Ribble Valley Borough Council  
Housing & Development Control

Application no: **3/2022/0500**

Address: **Land to the south of Chatburn Old Road Chatburn**

Proposal: **Technical Details Consent for residential development of upto 9 dwellings following Permission in Principle application 3/2018/0582 and appeal APP/T2350/W/19/3223816.**

PL 39

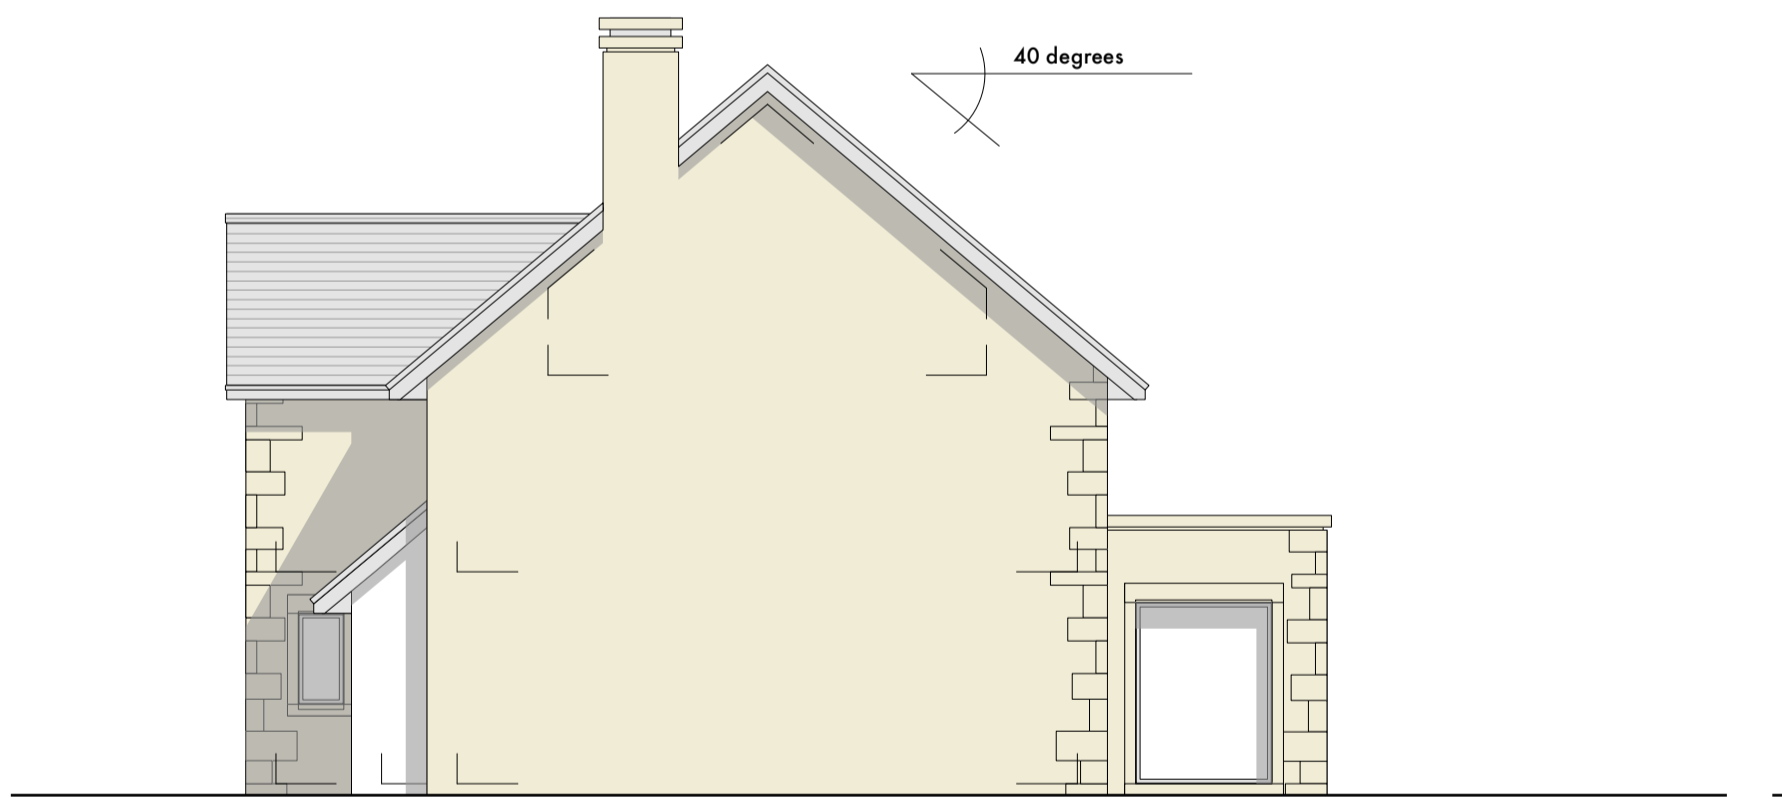
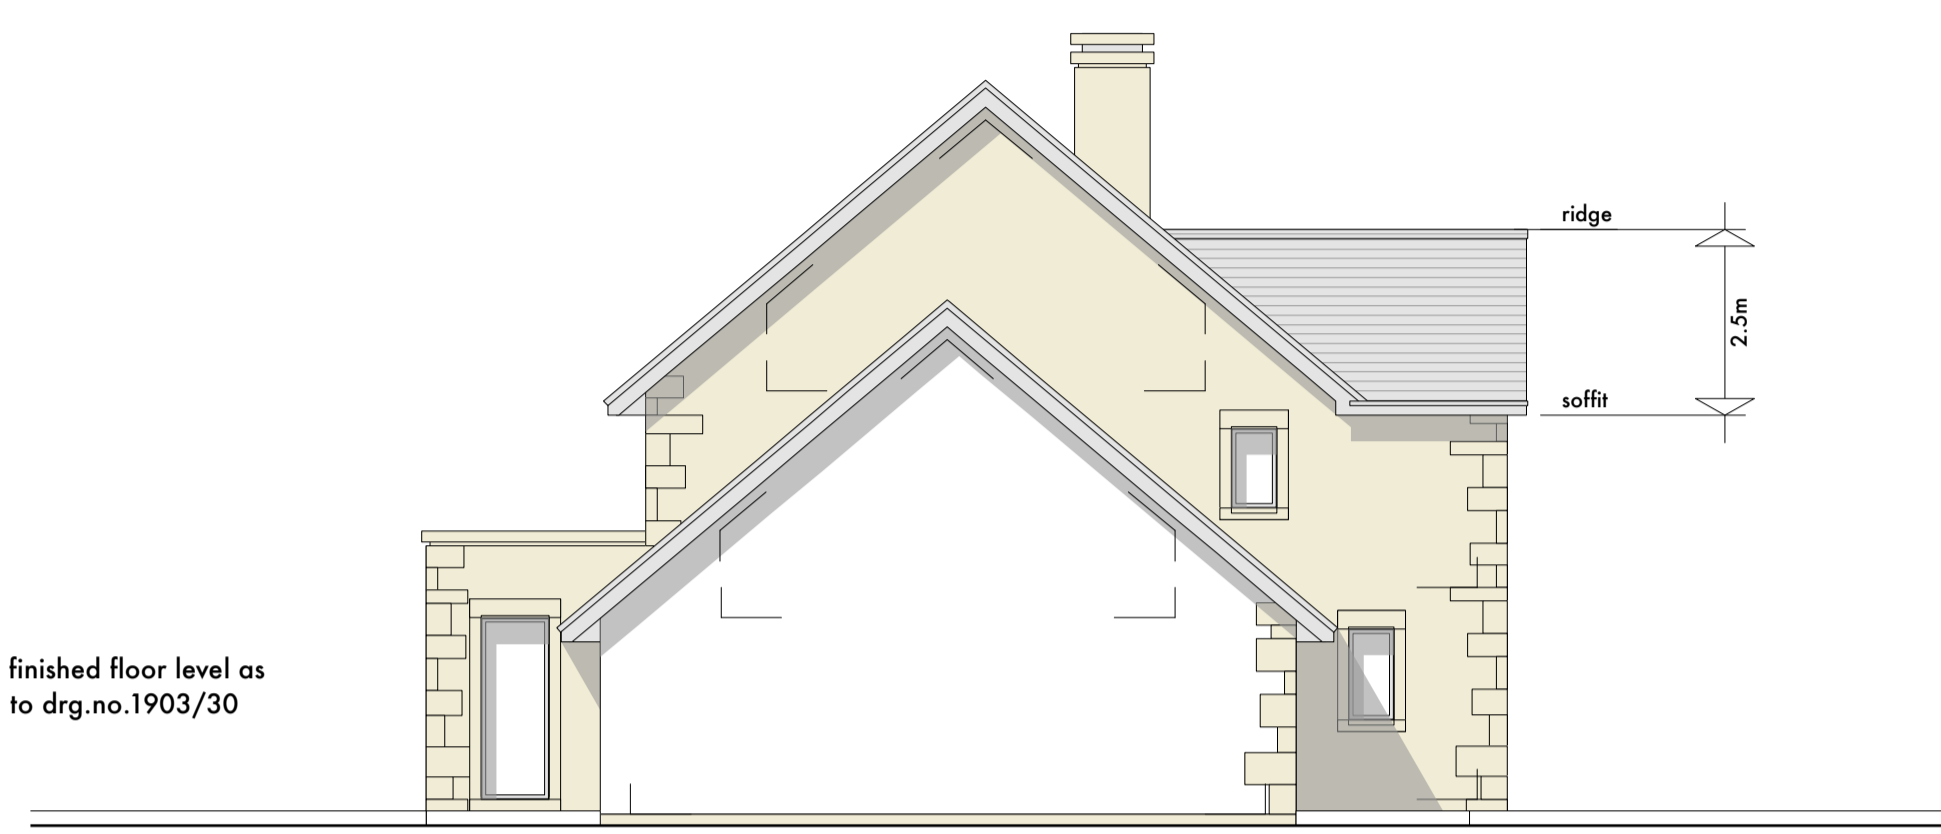
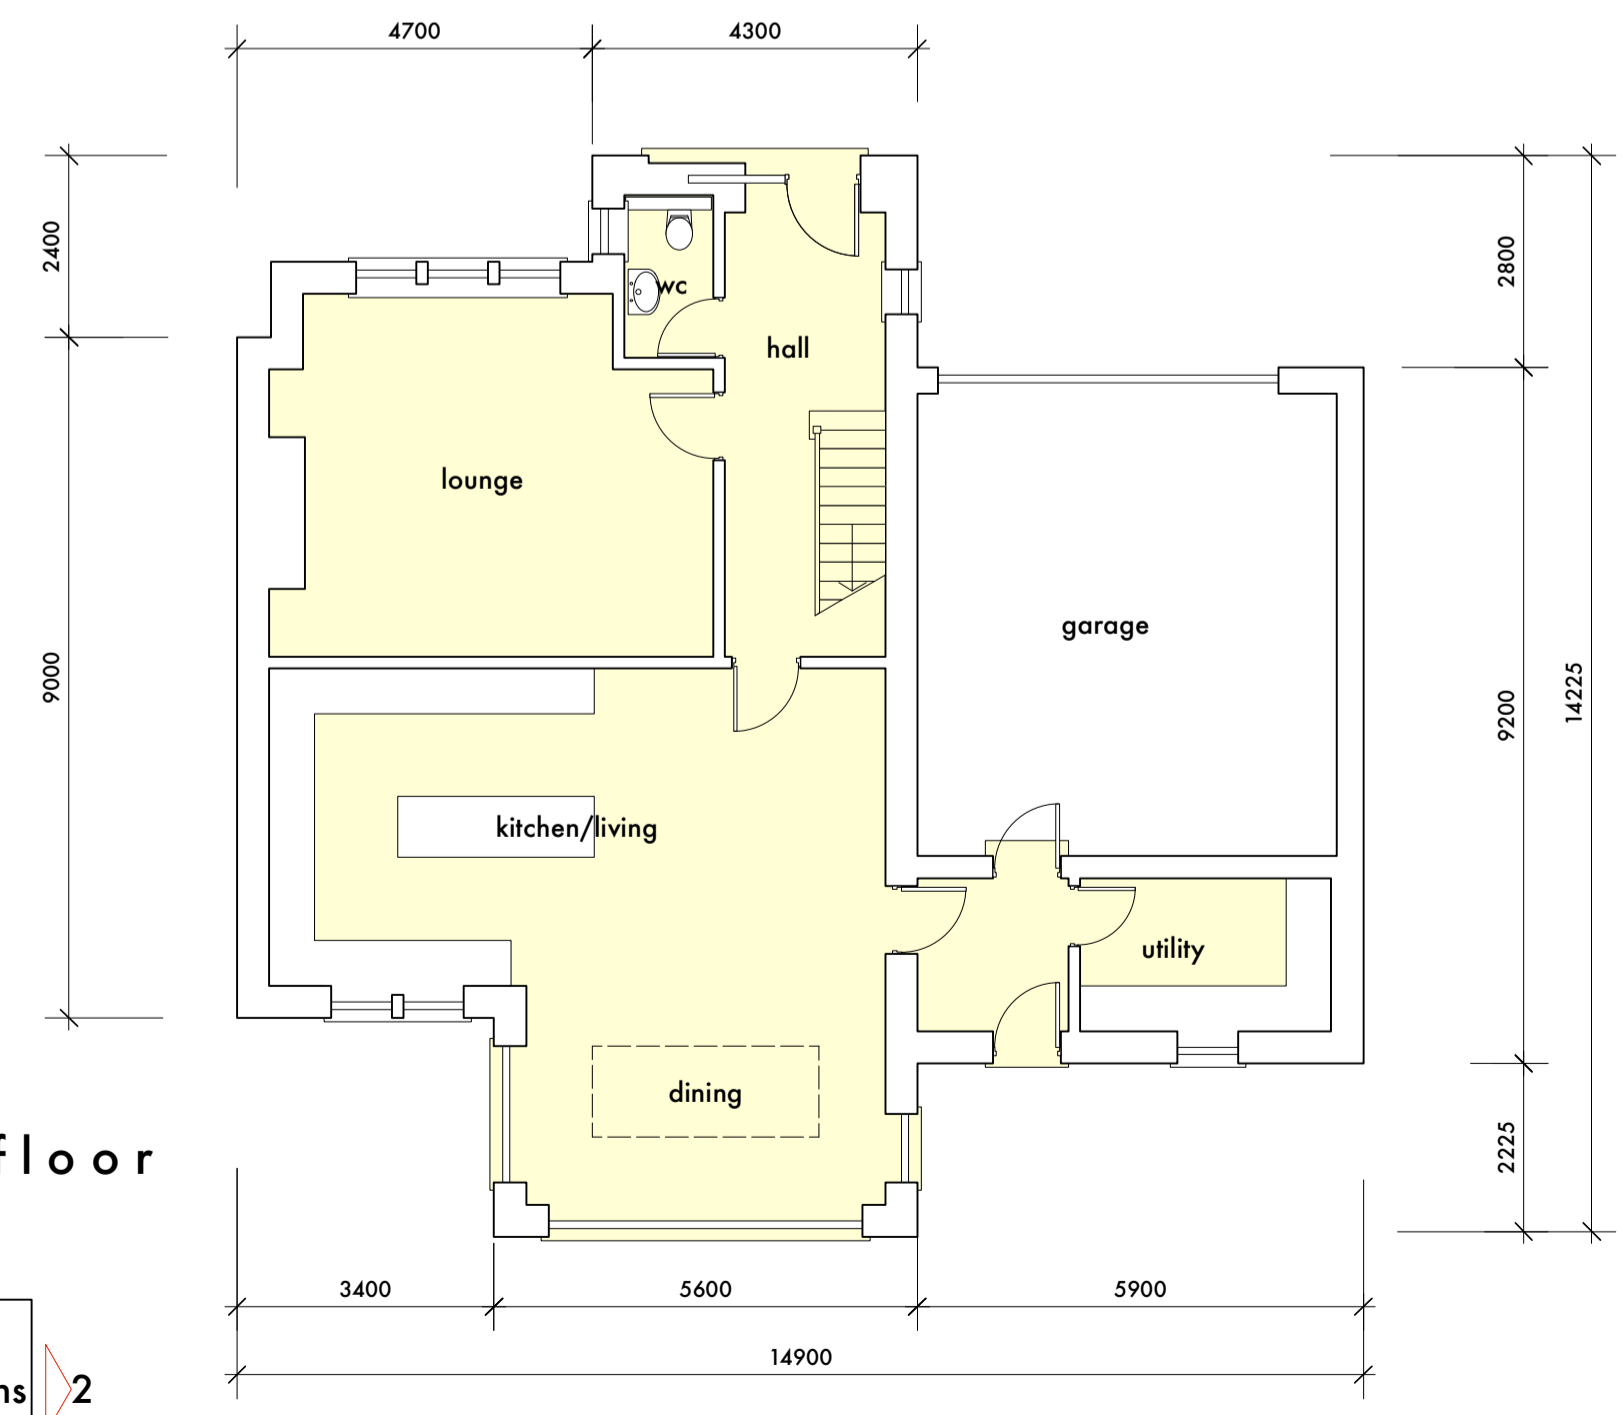
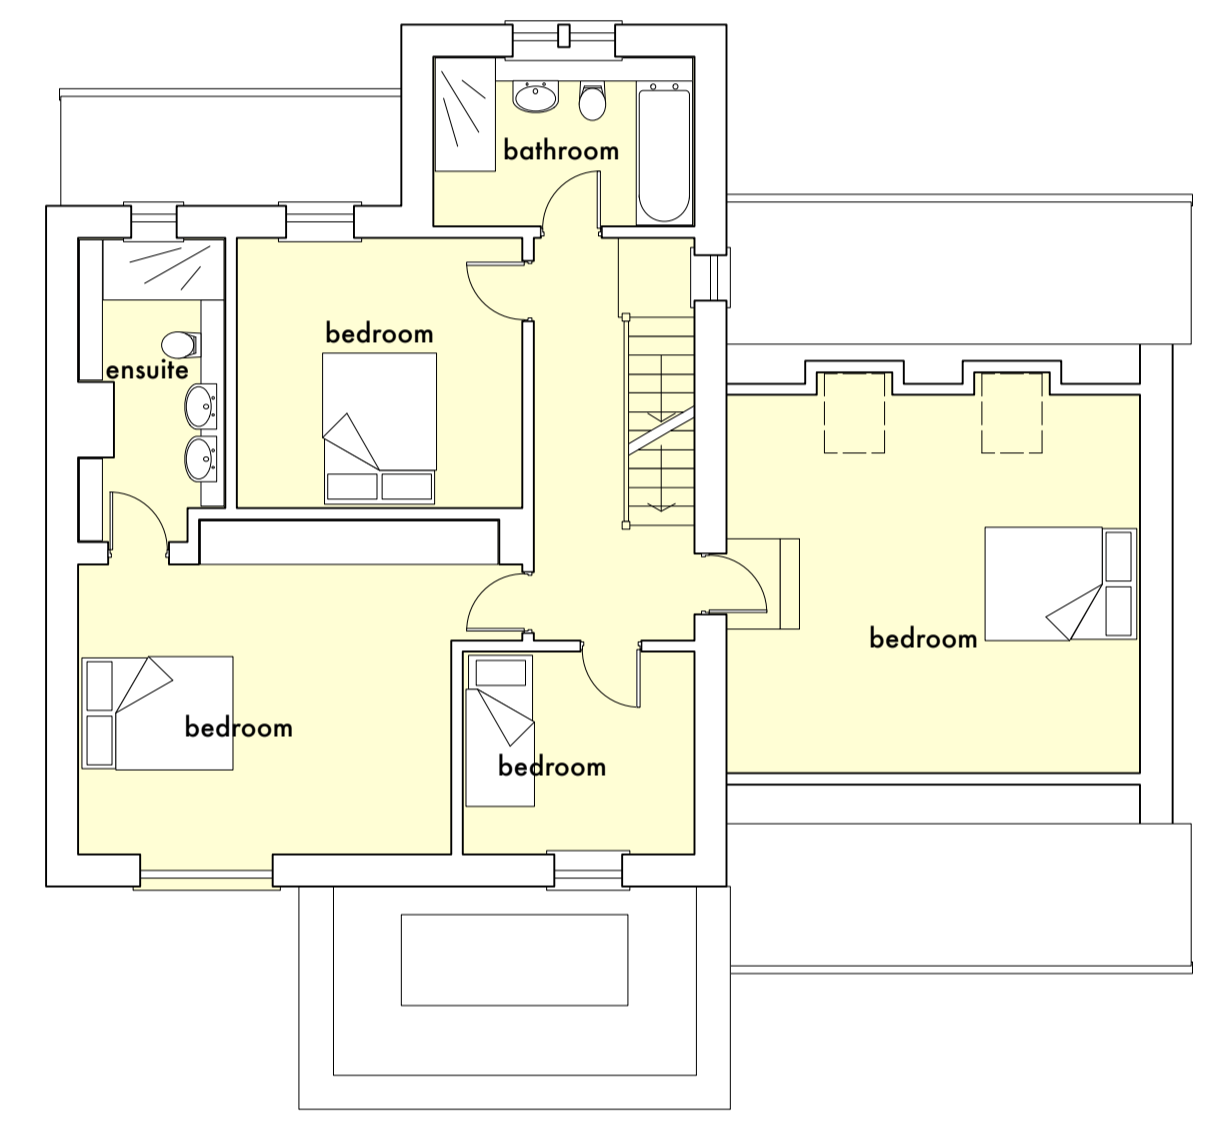
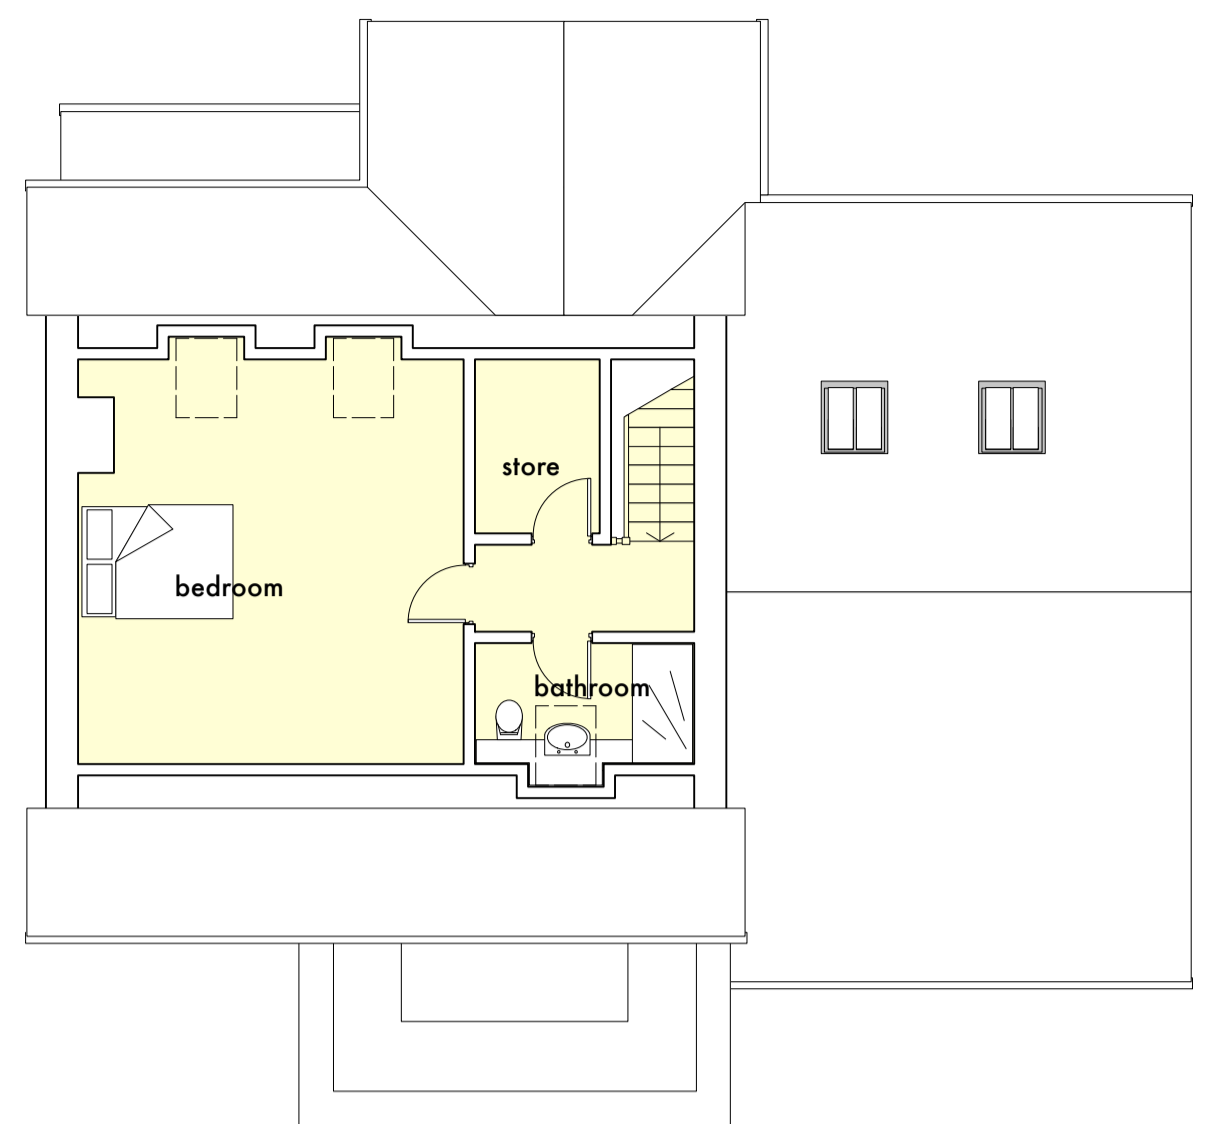
However, the LHA require amendments to be made to Plots 3 and 6 driveways. This is because should two car parking spaces be provided on the driveway, the width of the two combined spaces should measure a minimum of 5.3m given that one of the spaces is bound by the dwelling.

The amendment should be shown on a revised plan.
